**Site: Brookfield Barn- Land North Of Newlands Delaware Farm Hever Road Edenbridge
Kent TN8 7LD**

Proposal: Non-Material Amendment to 23/01907/MMA- Amendment to 22/02926/CONVAR related to 21/01300/FUL for conversion of existing building to a detached dwelling with associated access and landscaping.

Please find enclosed revised drawings for a Non-Material Amendment to SE/23/01907/MMA. The following plans are enclosed to address the amendments sought:

1 PLAN
 Proposed Roof Plan

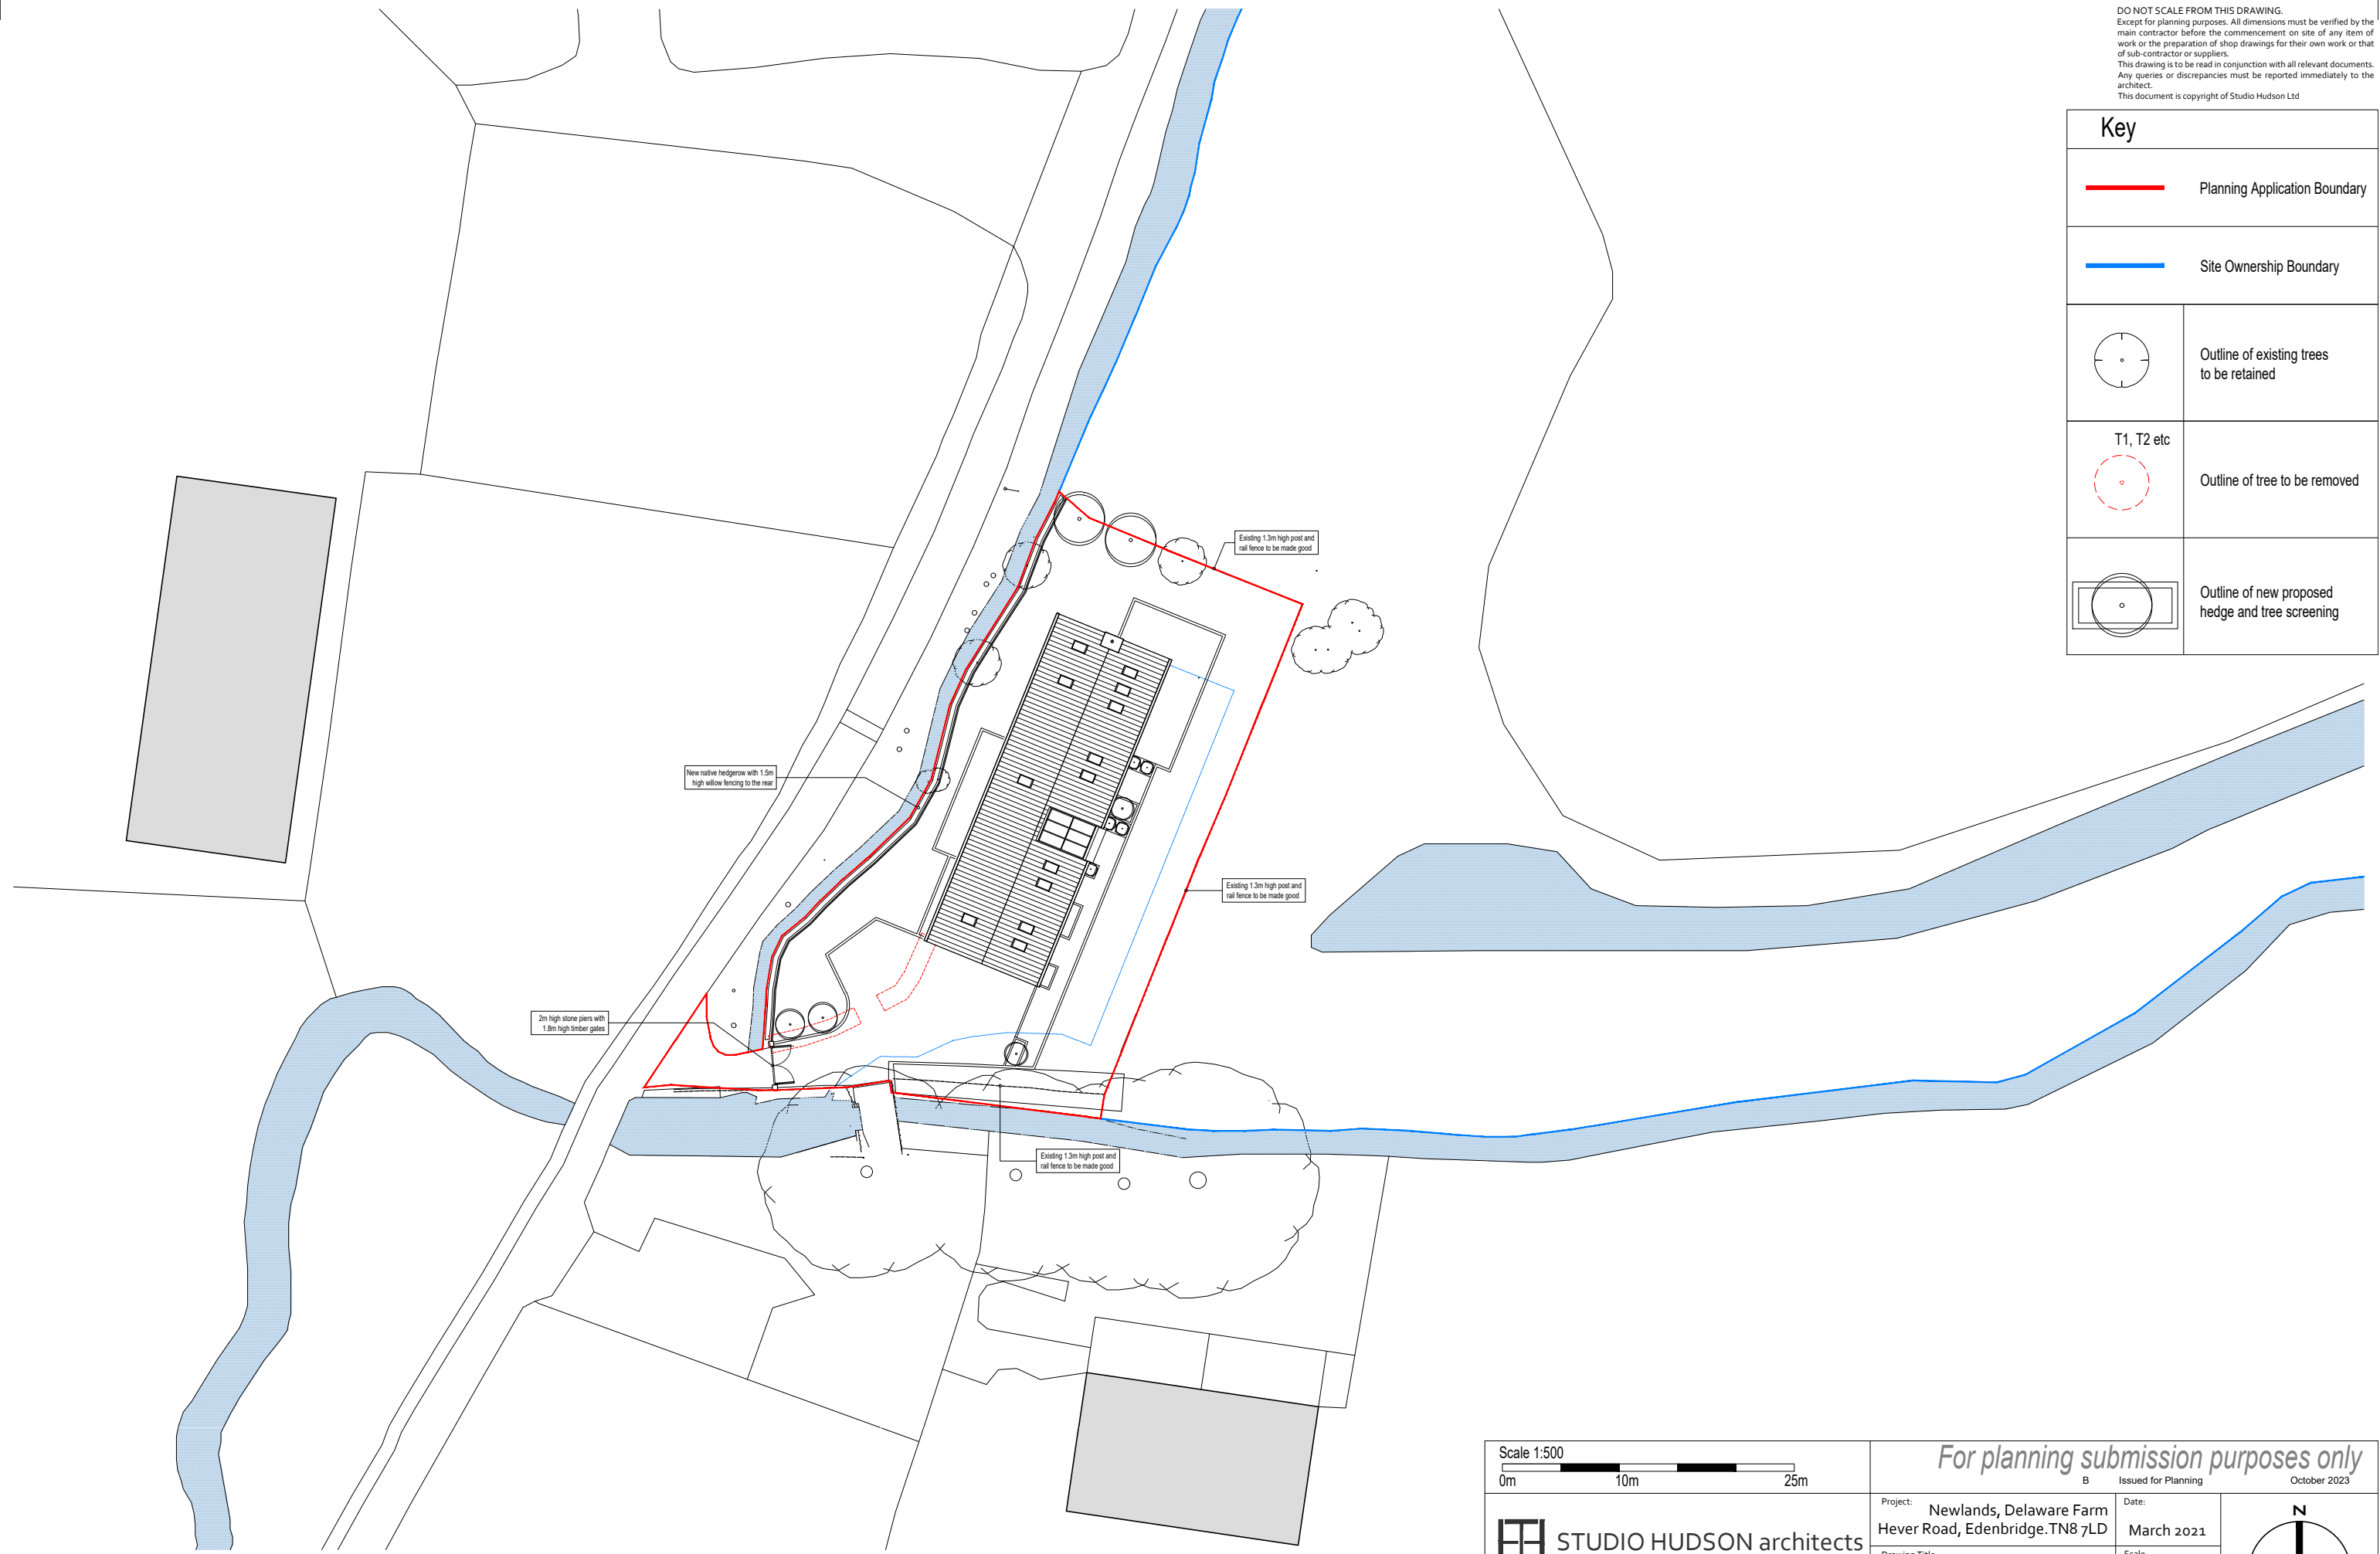
- Deletion of 2 roof lights to the west(front facing) roof slope
- Switched position of en-suite and dressing area to Bed 1
- Obscure glazing to west (front elevation) boot room door
